**Project No: PR-2023-009652 Date: 02/26/2025 Agenda Item: #5 Zone Atlas Page: C-10**

**Request: Subdivision of Land Major for an approximately 19 acre property and Sidewalk Waiver to allow 6-foot sidewalk width in an Urban Center.**

### **Application For: VA-2025-00023 – SIDEWALK WAIVER**

*Project Name: WESTERLY PORTION OF TRACT 1, SUMMARY PLAT, 68.75 ACRE TRACT & 66.15 ACRE TRACT, PARADISE HILLS, TOWN OF ALAMEDA GRANT*

**7 PROPOSED TYPICAL SECTION - UNSER BLVD. AT INTERSECTION APPROACH**

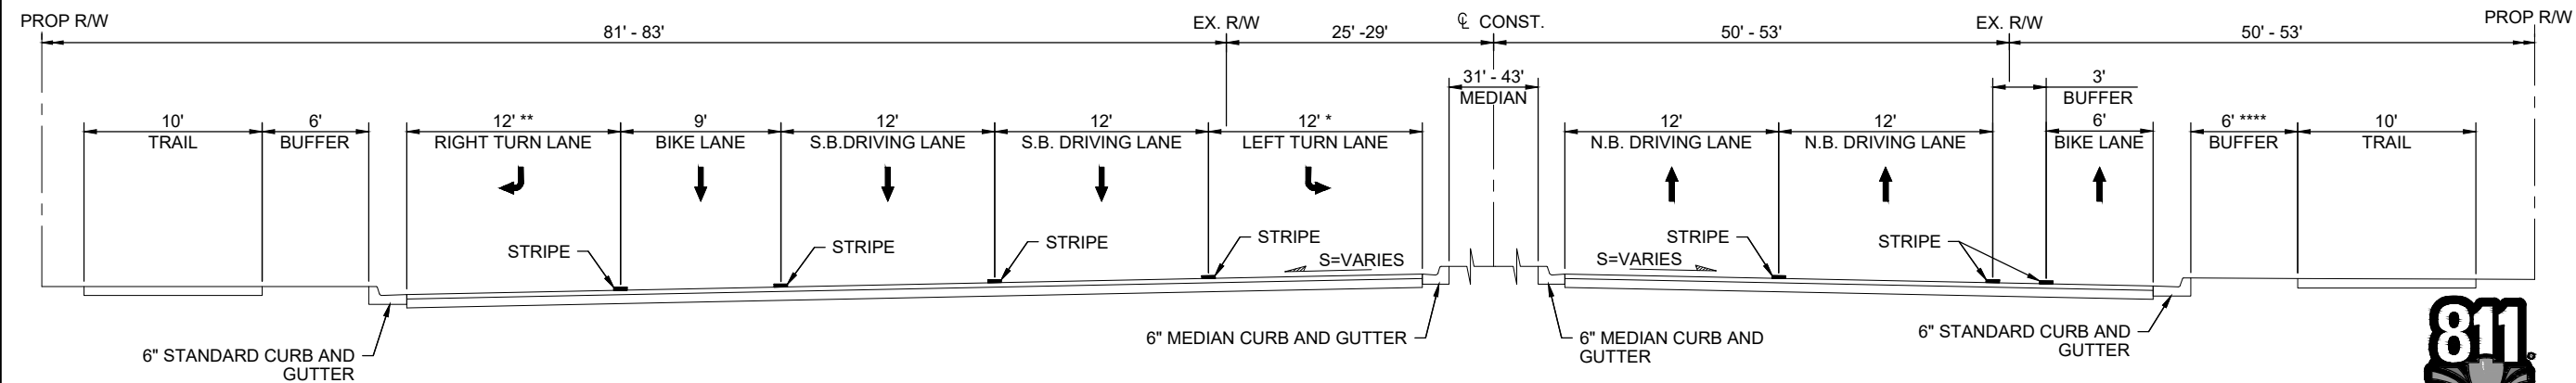
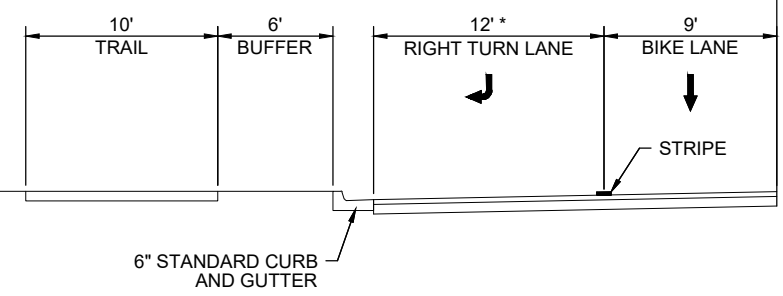
Provide a detail showing where the trail will be accommodated in the ROW along Unser.

The Long Range Bikeway System Map (LRBS) shows proposed 10' wide multi-use paved trail. Phase 1 of the City's Unser Widening project will include trail on both sides of Unser just south of Paseo del Norte. The project site is not located within the Phase I termini. Please coordinate with DMD – Jill Cuppernell. It is likely there will need to be paved trail included on the infrastructure list – and it could be processed as a Procedure C for the City to build at a future date, or the applicant may be required to build. See below reference to the IDO.
